A46 Newark Bypass

6.10 Environmental Statement Scoping Opinion

SCOPING OPINION

Proposed A46 Newark Bypass

**Figure 2.1: Noise measurement locations**

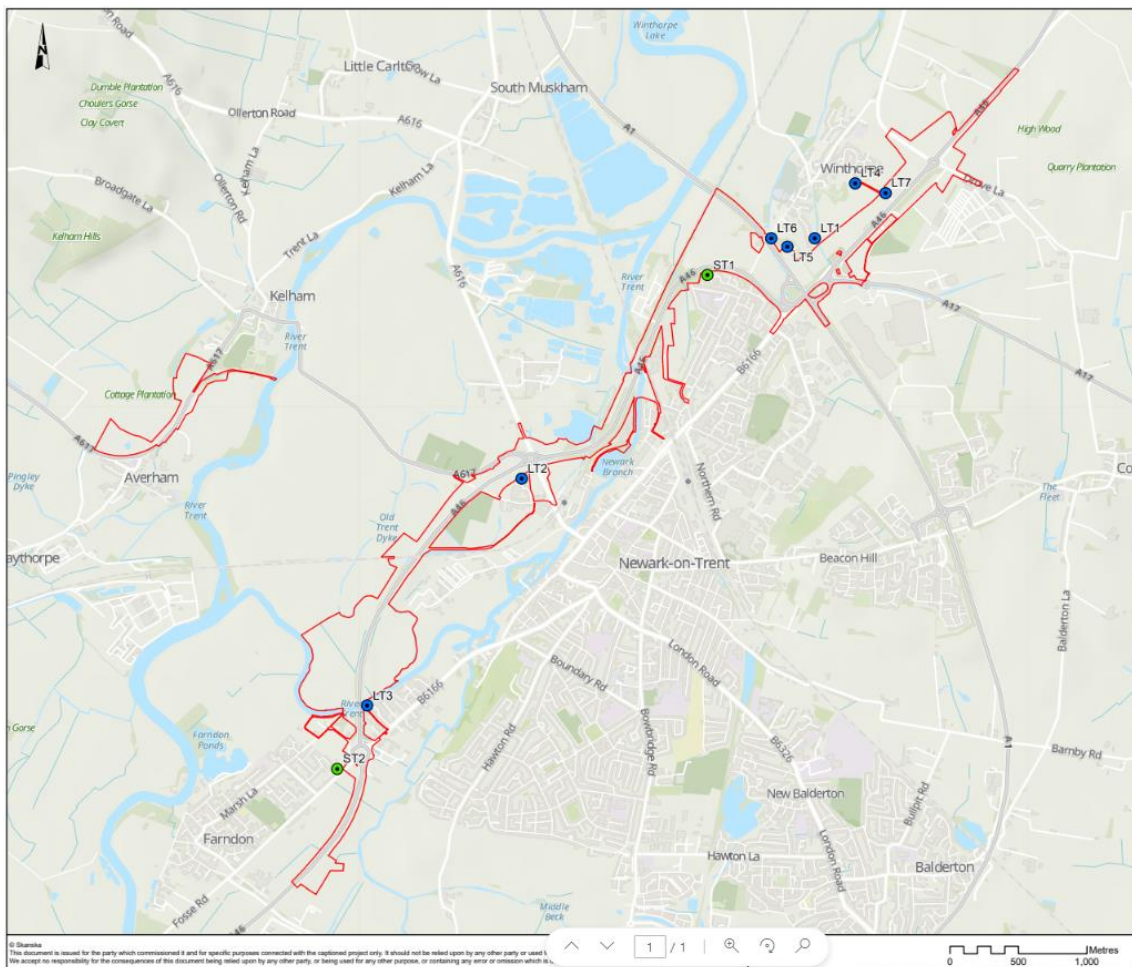
ID	Ref	Description	Inspectorate's comments
3.6.2	12.4.2	Baseline Noise Monitoring Locations	The Scoping Report indicates that some noise monitoring locations were influenced by stakeholder requests. The ES should detail the consultation undertaken and the methodology for the selection of baseline noise monitoring locations.
